Your ref:	Hospital of St. John and St. ...	Please reply to:	Fraser Fikrie
Our ref:	23/07223/FULL	Tel No:	0753424 7967
		Fee Queries:	0207 641 6500;
		Email:	planningreception@westminster.gov.uk;
Mr Gavin Curwen Edgeplan Ltd Causeway House, 13 The Causeway Teddington TW11 0JR United Kingdom		Incomplete Applications Town Planning & Building Control City of Westminster PO Box 732 Redhill, RH1 9FL	
		1 November 2023

Address: Hospital, 60 Grove End Road, London, NW8 9NH,

Proposal: Demolition of a ramp in a conservation area, infilling of terrace wall, lower basement level by 0.7 metres and replacement of windows and doors with upvc glazing

DRAWING TITLE:
Existing and Proposed NW Elevation

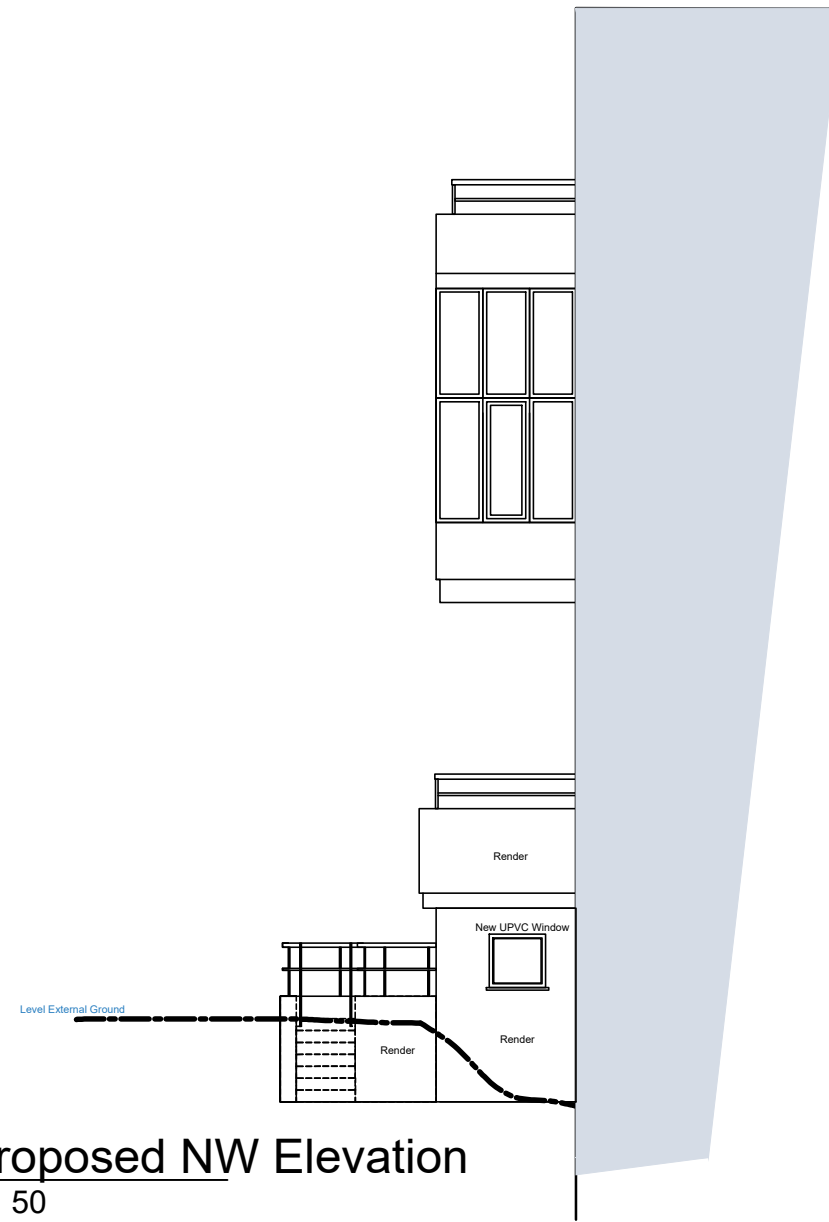
- 1 Some or all of the drawings submitted with your application do not include a scale bar, please amend the drawings to ensure all drawings include a scale bar.
- 2 Please provide a sustainable design statement.
